Non Material Amendment

30 Priory Avenue
Harlow, CM21 0HJ

Status: Planning
 Scale: 1:100@A3
 Drawing No: 0361-1200-P7

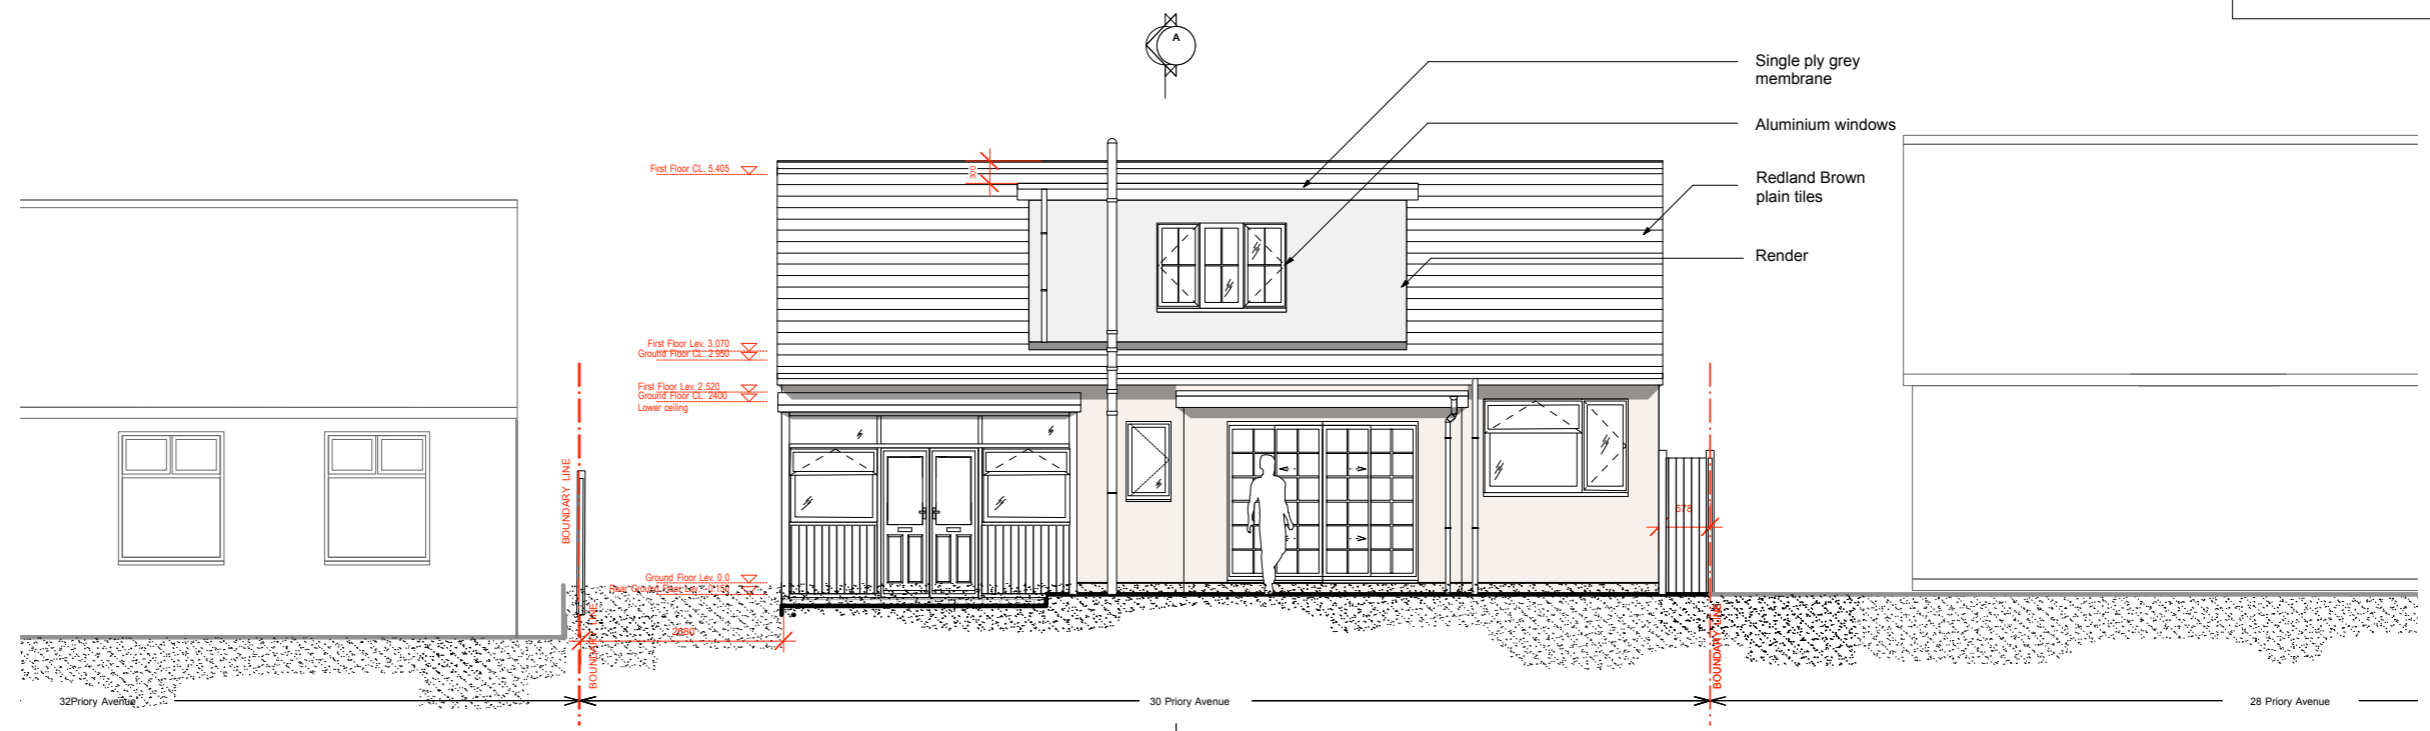
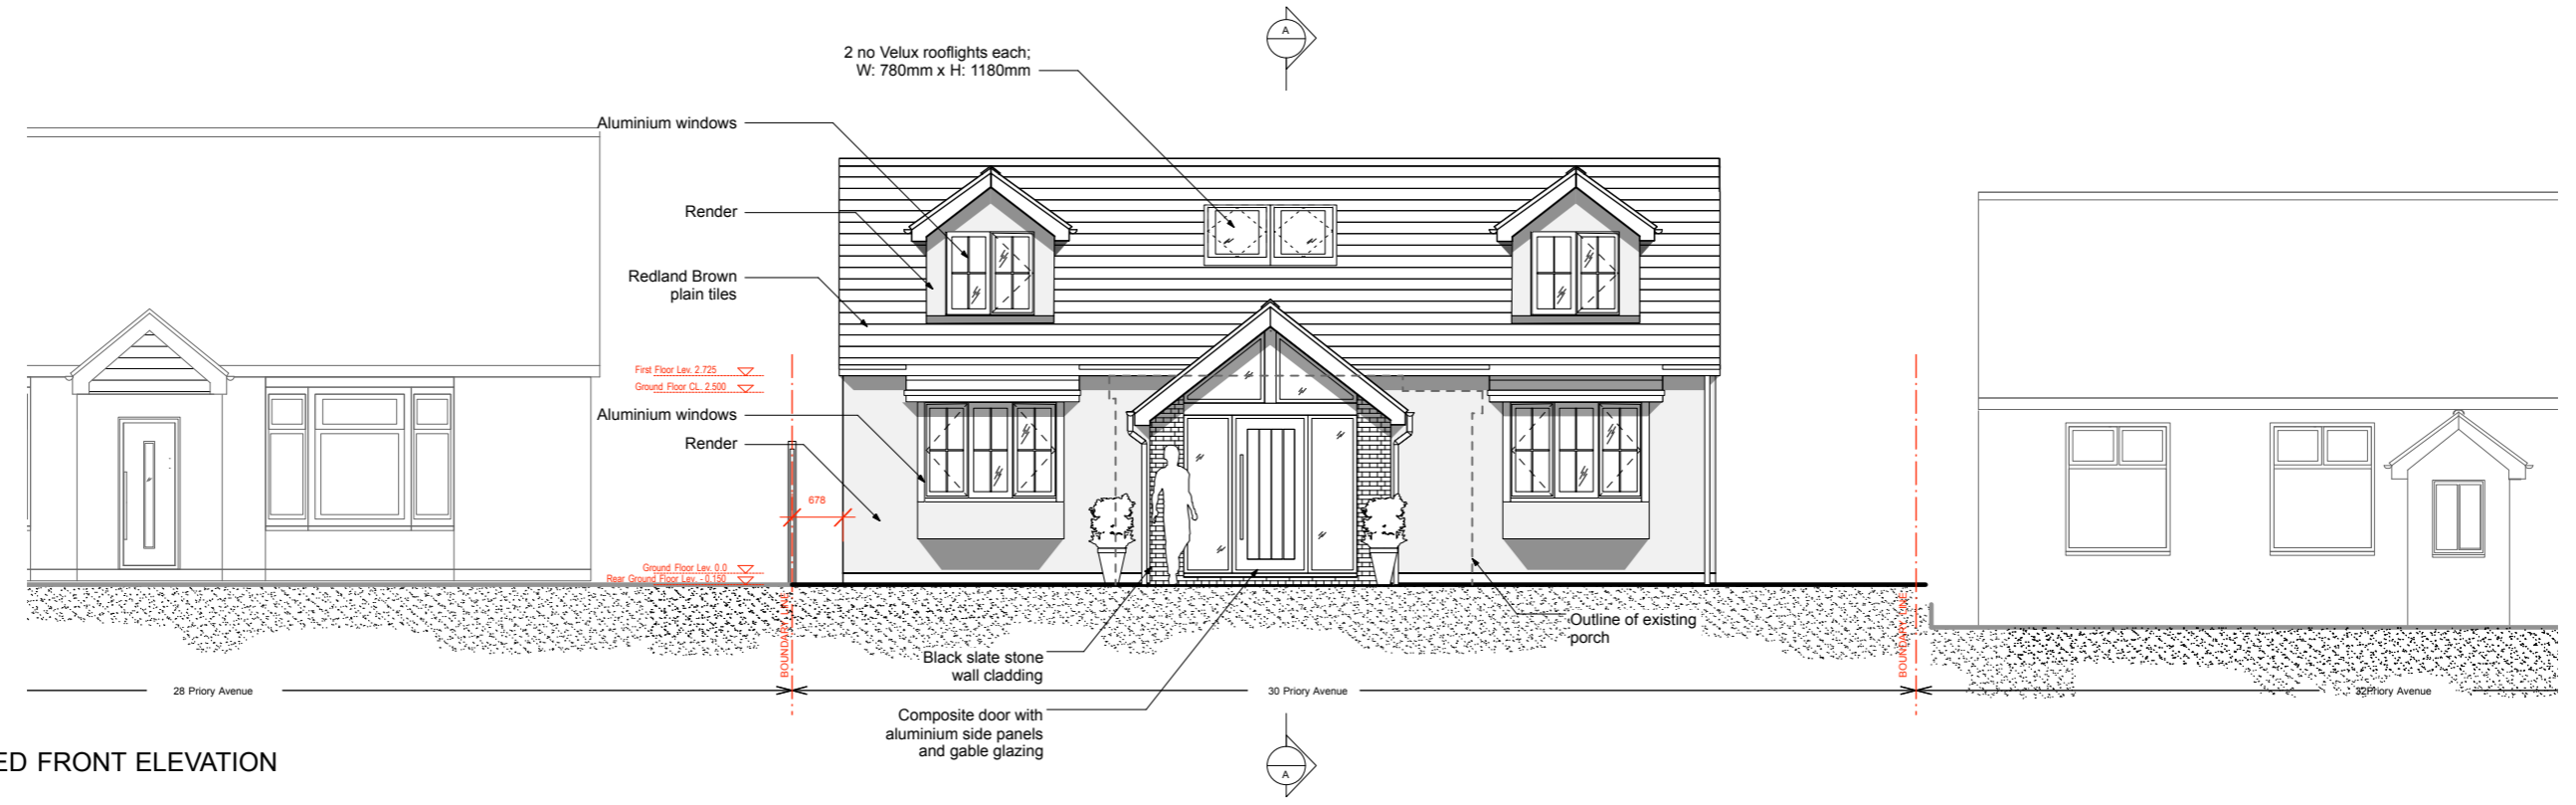
Plain black tiles to be changed to Redland Brown plain tile.

Redland 10001872 Concrete Plain Tile 6151 Brown 02
